CLEAR VIEW INDUSTRIAL PARK, FILING 2A

GRADING, STORM AND EROSION CONTROL PLANS

SHEET TITLE: EXISTING SITE PLAN

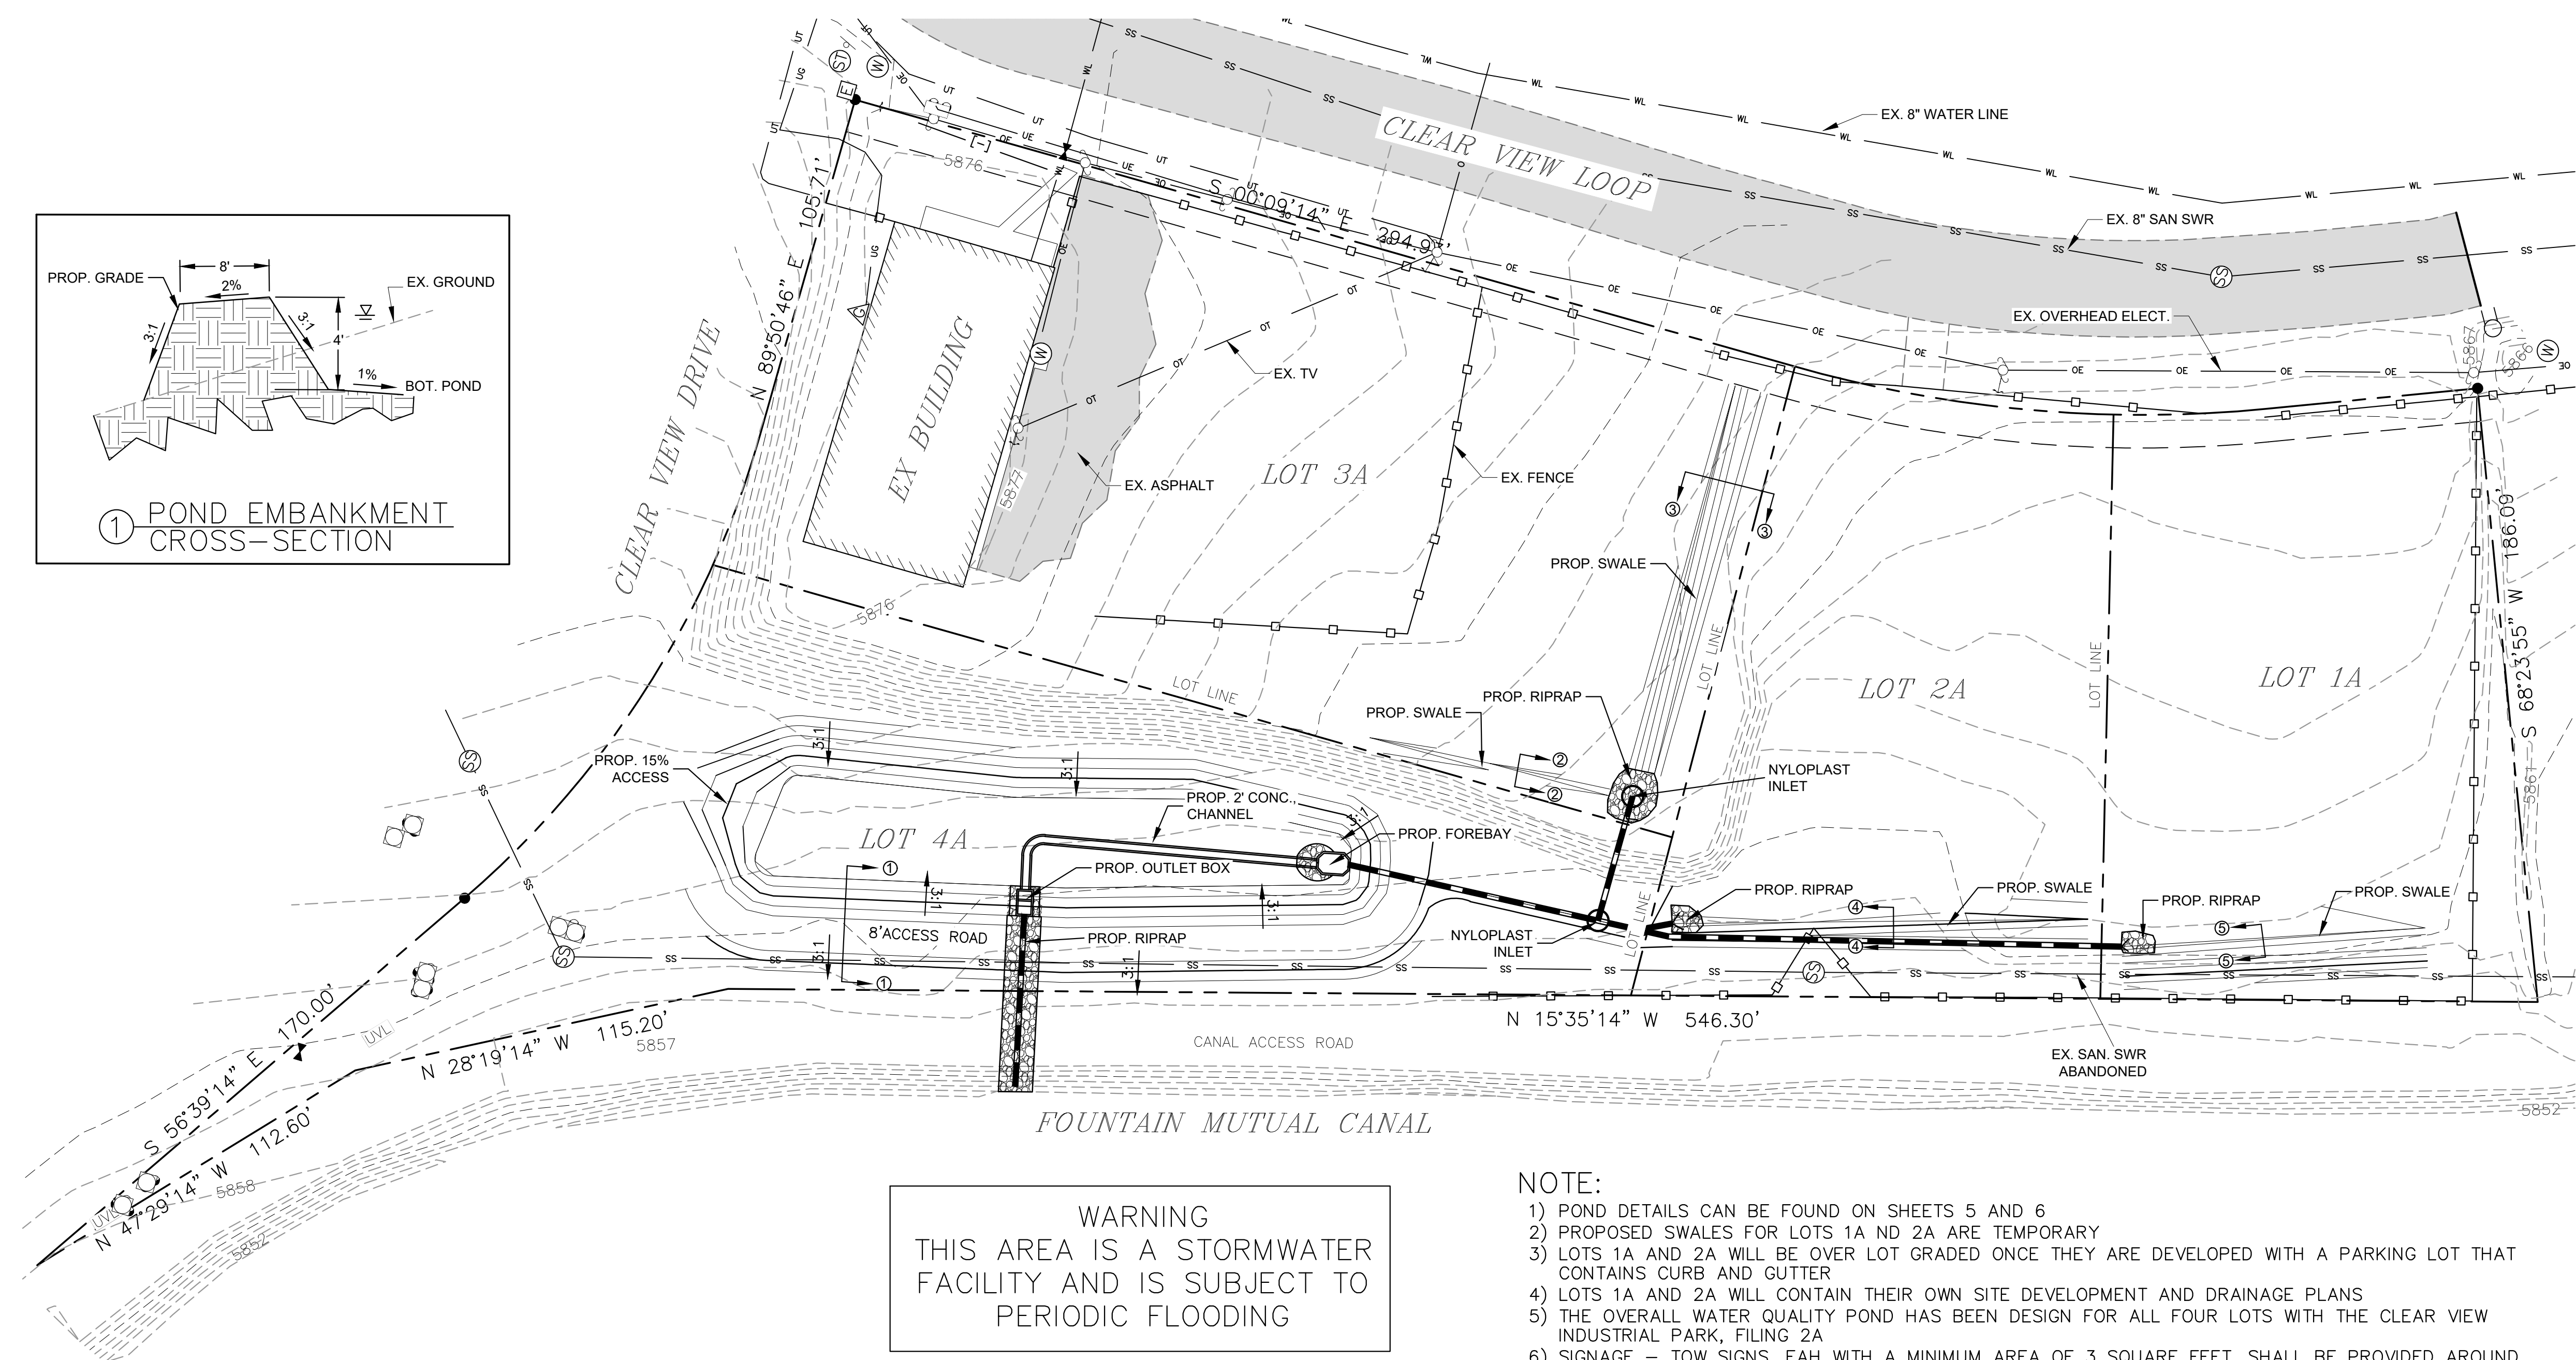
Fix. This is contradictory from the proposed design which locates a pond in Lot 4A for the overall subdivision.

Show all existing easements.

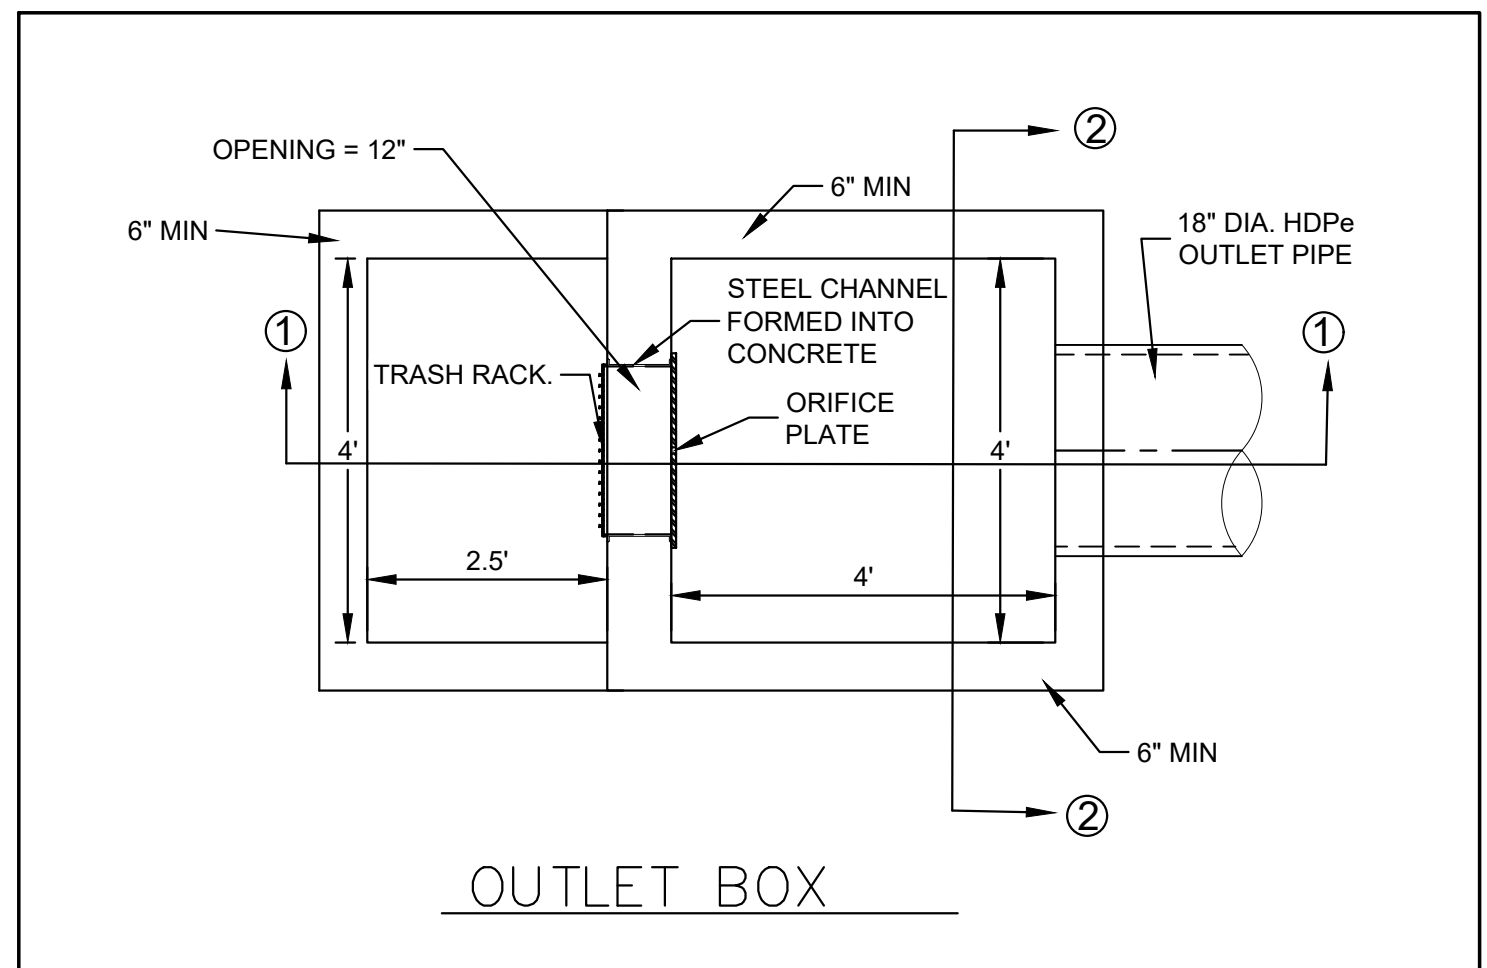
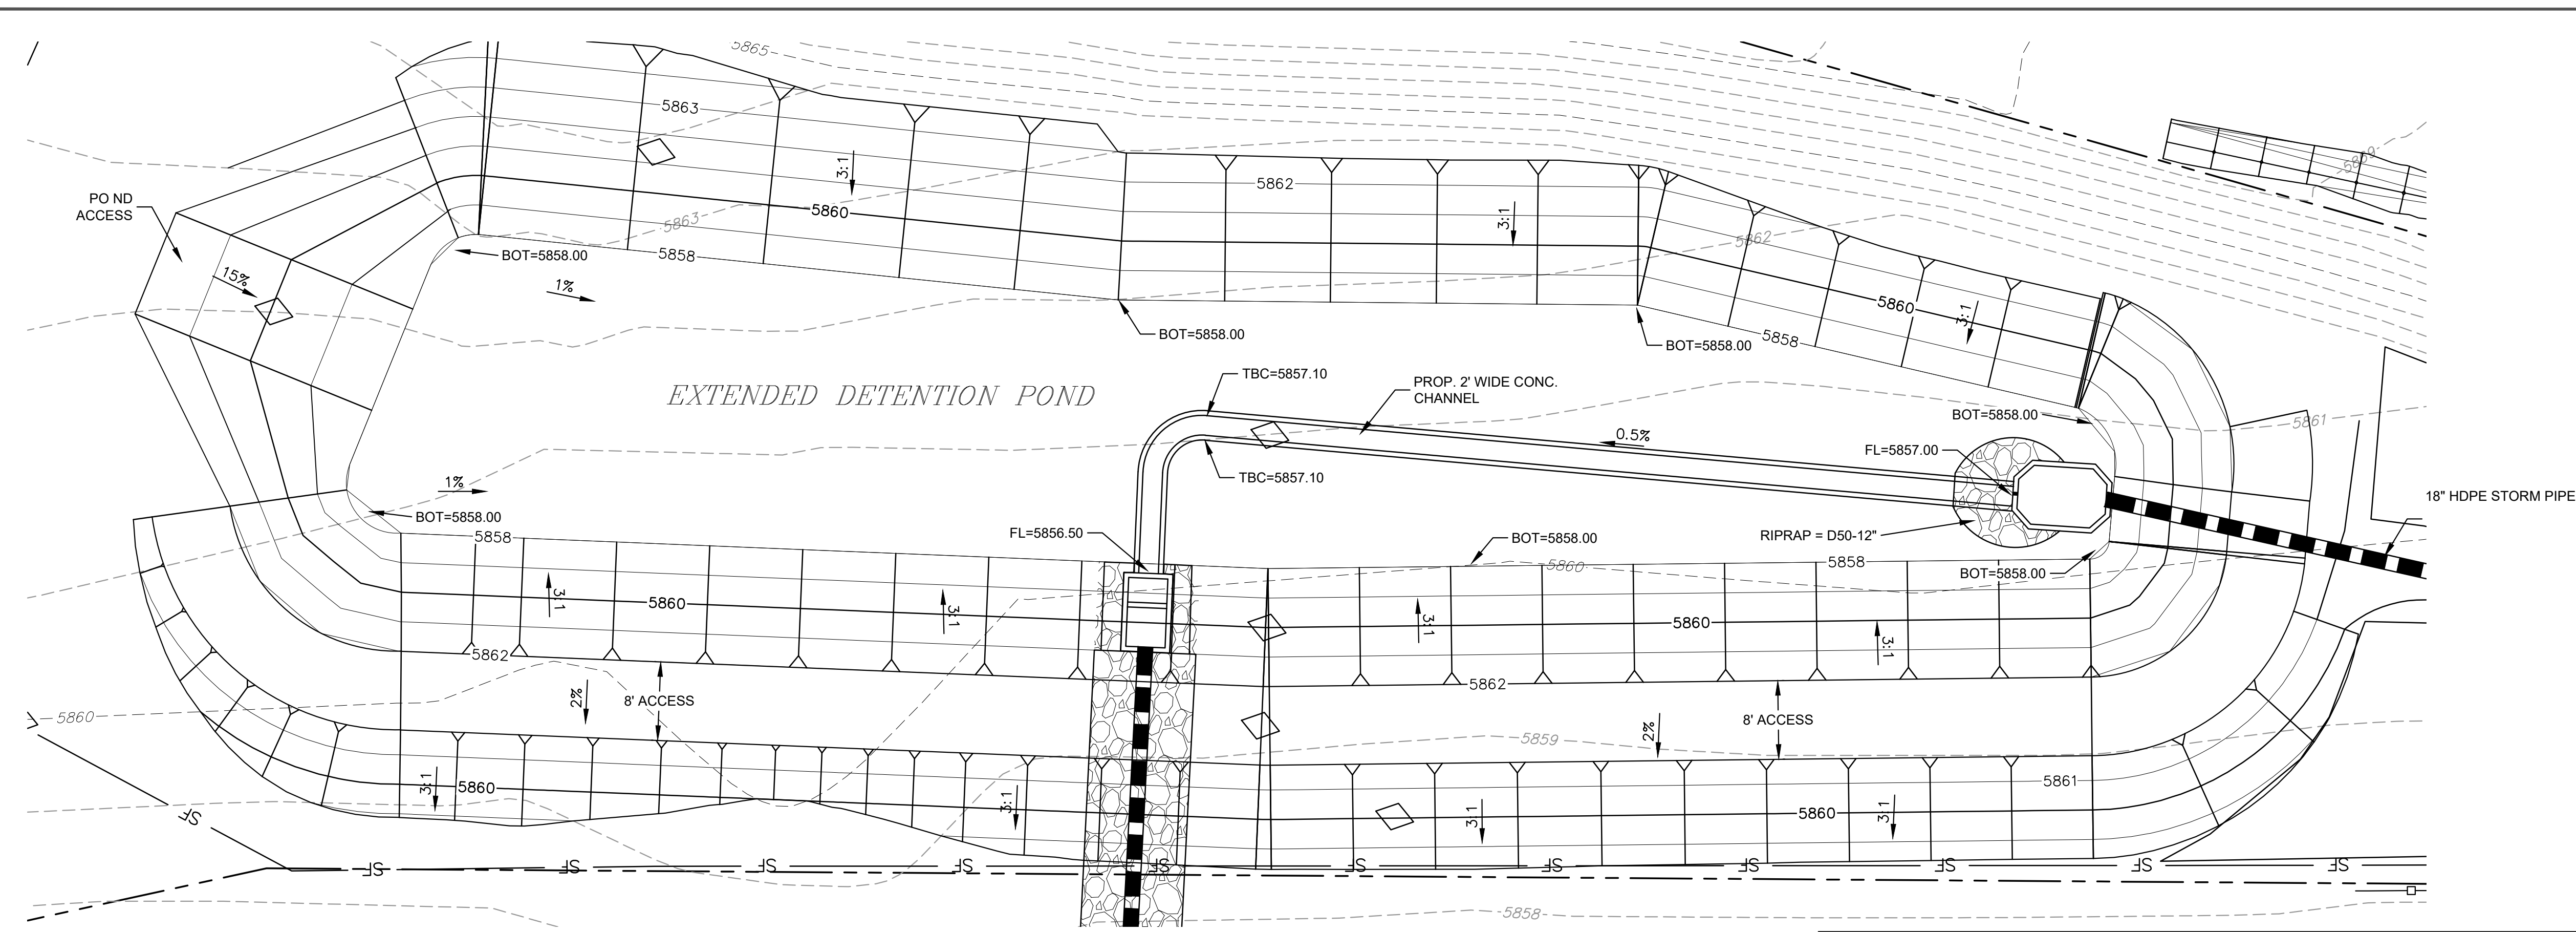
Revise access slope to drain towards the pond

Revise embankment width to a minimum 12' per DCM 11.3.3

Update cross section to show the property line and dimension label to the property line.

Submit a geotech recommendation for the embankment design (DCM 11.3.3) and identify the required compaction for the embankment.

Revise pond bottom to 3%.

provide major contour labels.

Provide detail or call out maintenance access width and stabilized surfacing.

Revise to 12% per DCM 11.2.2

Revise embankment grade

Provide a letter from Fountain Mutual Irrigation Co. confirming they have no objections to the proposed offsite improvements.

Proposed drainage way is in conflict with Lot 4A's access. See snippet to the right from the vacation/replat staff report (VA08004)

provide inlet calculation in the drainage report.

Drainage easement required for the pond.
